CITY OF ALBUQUERQUE

August 6, 2021

RE: **Mesa Del Sol Innovation Park
Montage Unit 6
Grading and Drainage Plan / Report
Engineers Stamp Date: None
(R16D003C)**

PROPOSED CONDITIONS BASIN MAP

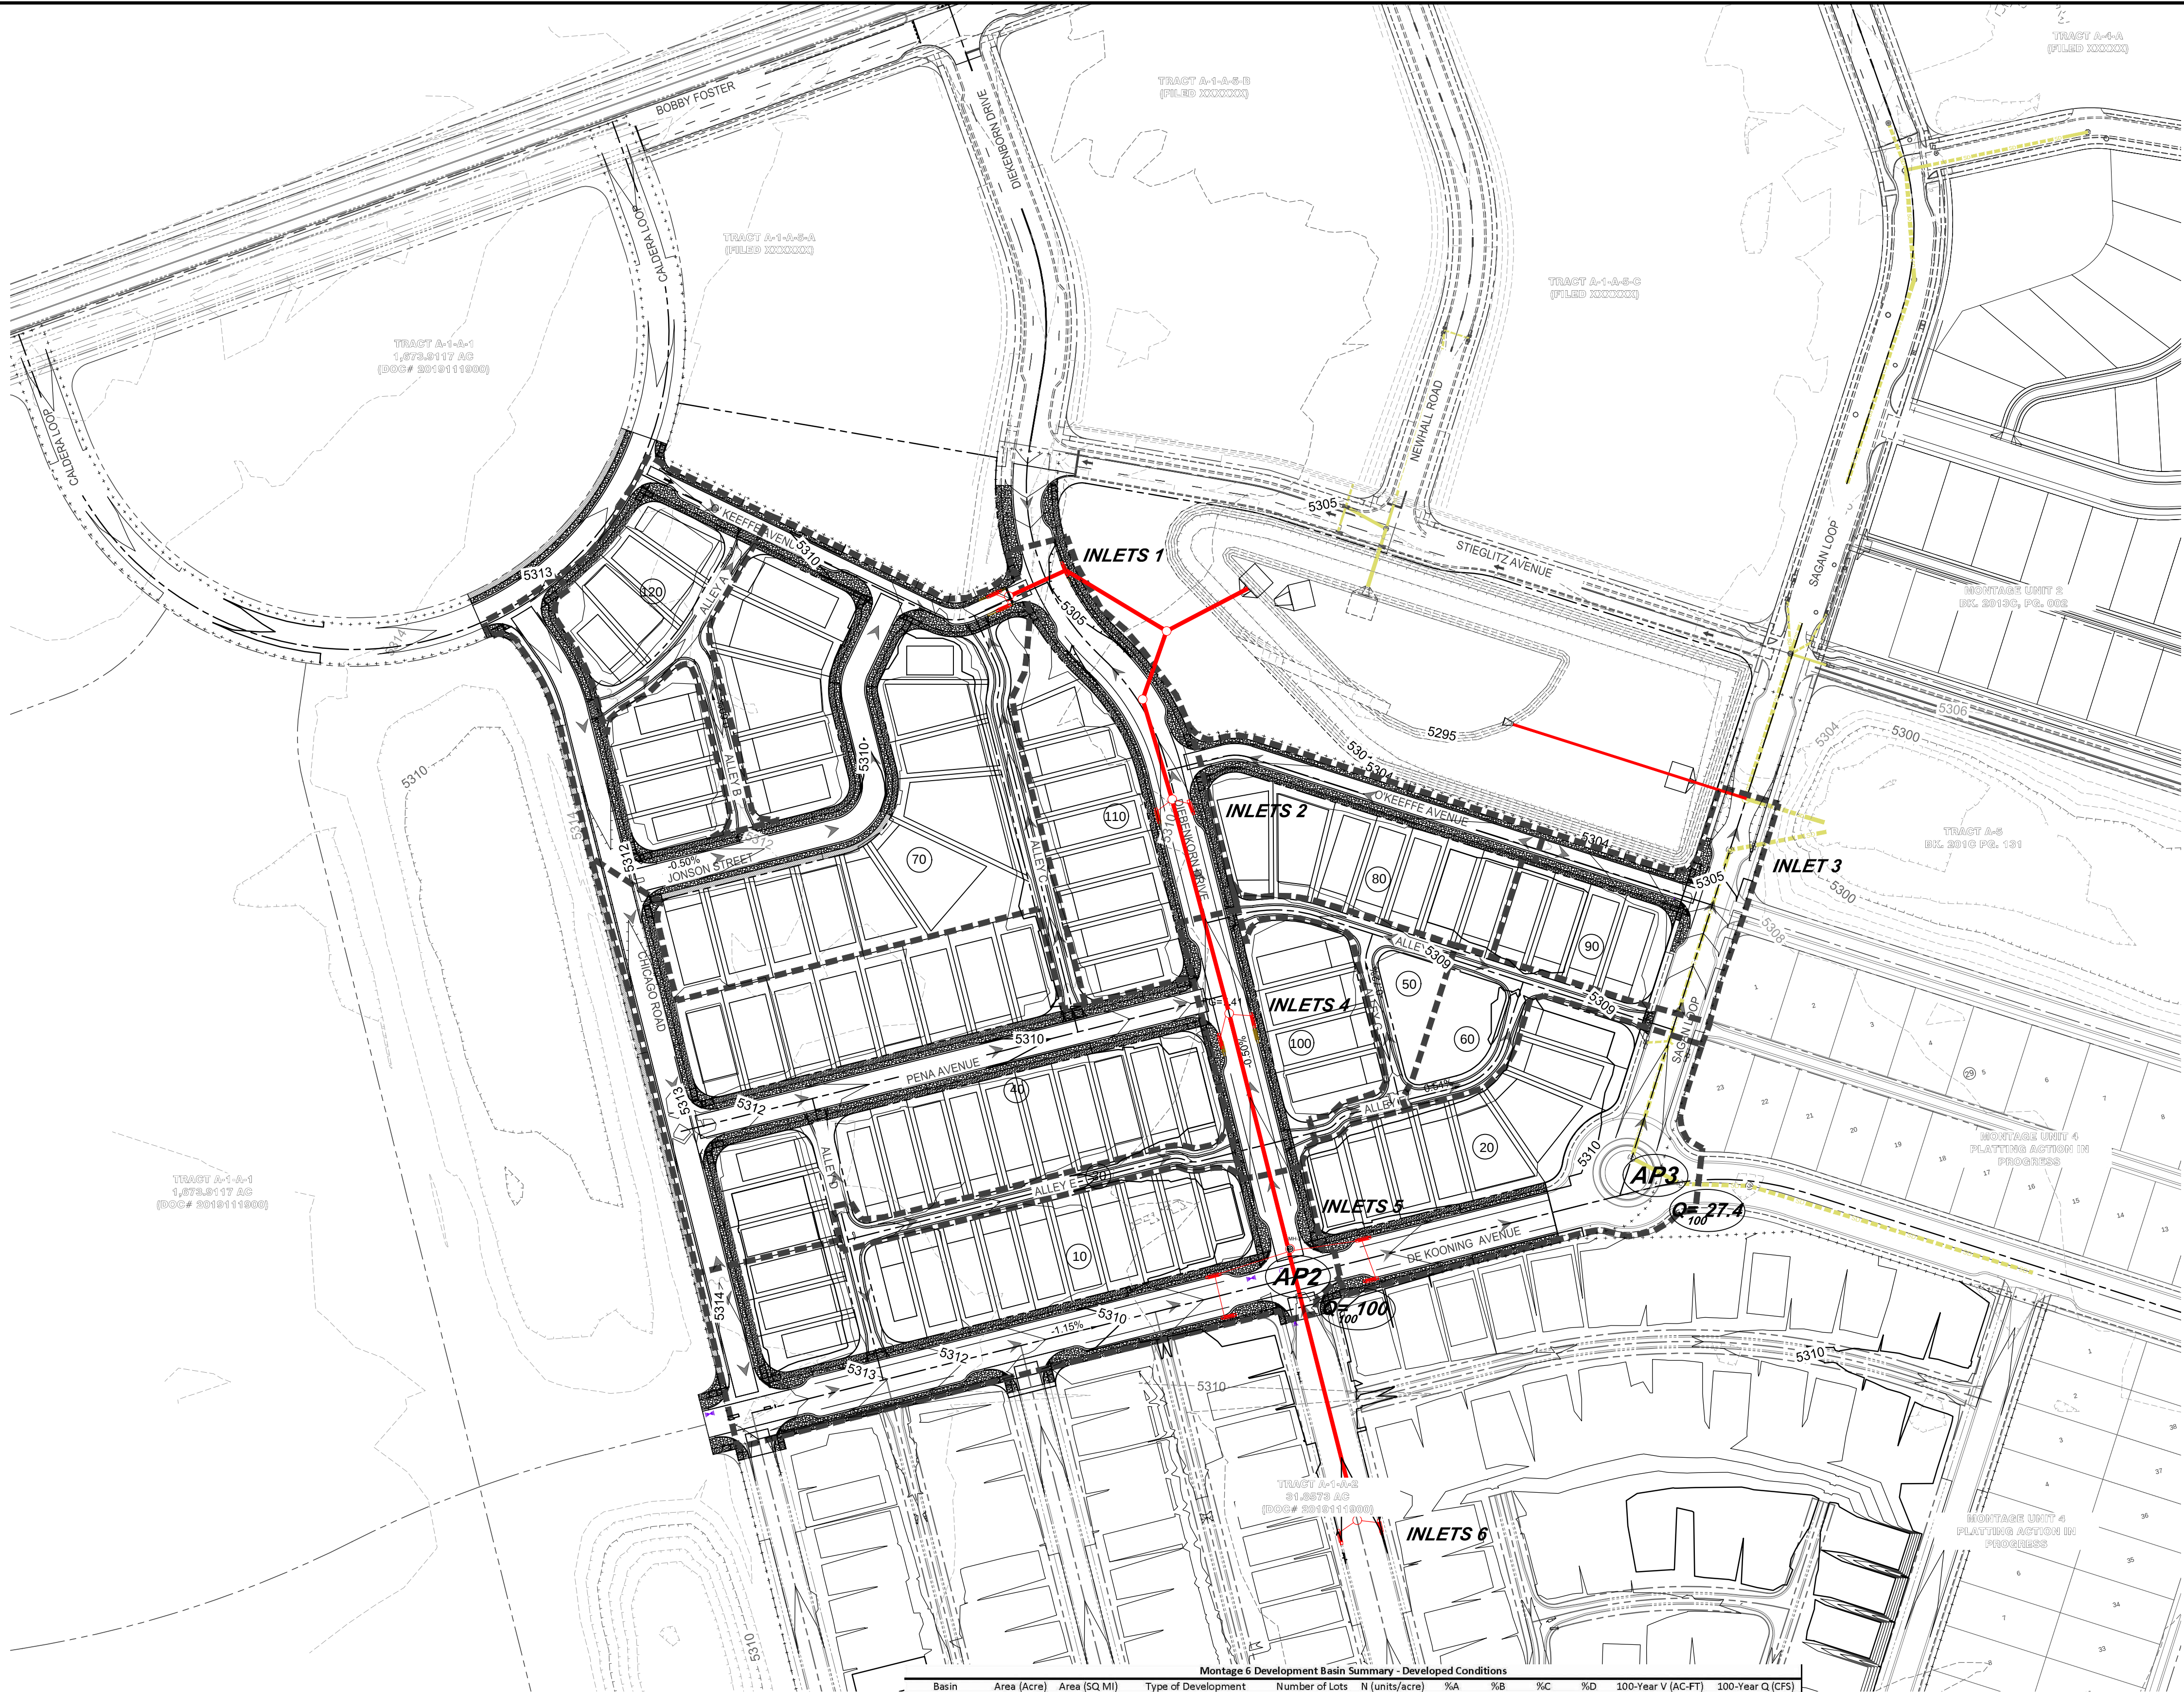
1. The report and drawings submitted must be stamped and signed by NM registered Professional Engineer. The report had a stamp but no signature.
2. In reviewing the grades and basin information provided, the divide between Basins 50 and 60 at Alley E and Alley G is not clear. There is nothing to indicate than flows would actually make the turn from eastbound Alley E to northbound Alley G. Can you clarify this with spot elevations or a grade break at this point?

3. Inlet 3 shows the cumulative Q amount of Basins 20, 60 and 90 being captured at this point, but the road appears to be crowned and that only half of this flow would reach this inlet. The other half looks to be captured by the inlet on the other side of the street which flows to a separate pond. Is this inlet and pond sized to capture and contain this additional flow? Please check and revise.

4. I am concerned that Inlet 2 is placed to capture a cumulative 39.4 cfs from the remaining Basins which is carried here with on-street flows. Please demonstrate that there is capacity in the street to capture and contain these flows without leaving the ROW or flooding the street. You may need to demonstrate some of the contributing flows are also kept within the ROW without hampering vehicular traffic.
